From: Julie Grieves on behalf of Planning.Responses
Sent: 05 April 2019 10:10
To: Planning Scanning
Subject: FW: FP/64/19/PL Mow Cottage

Can you arrange for the GCN surveys to be carried out as we will need to have these before determination. Please also note the comments in respect of water voles and dormice. If it is not possible to ensure the appropriate buffer

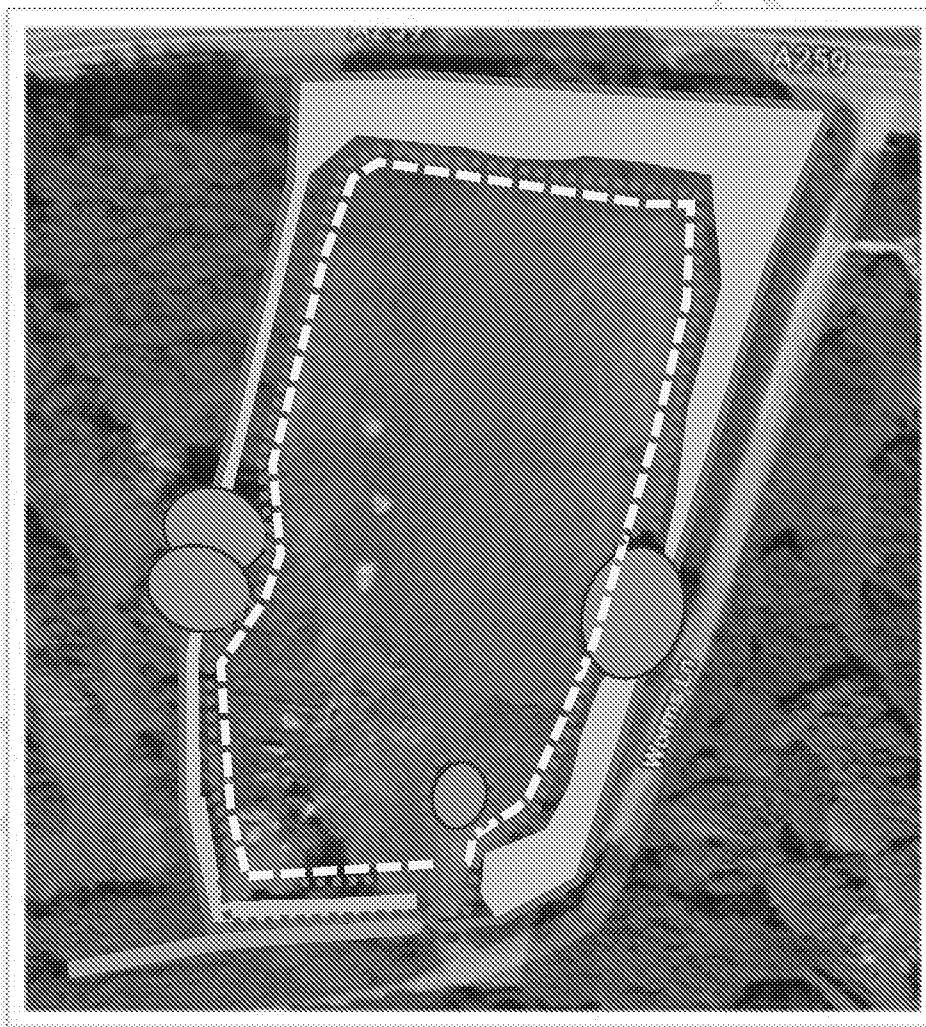
zones, then species specific surveys may also be required. Finally, could the mitigation plan in the ecology report be updated to show the location of a wildlife pond.
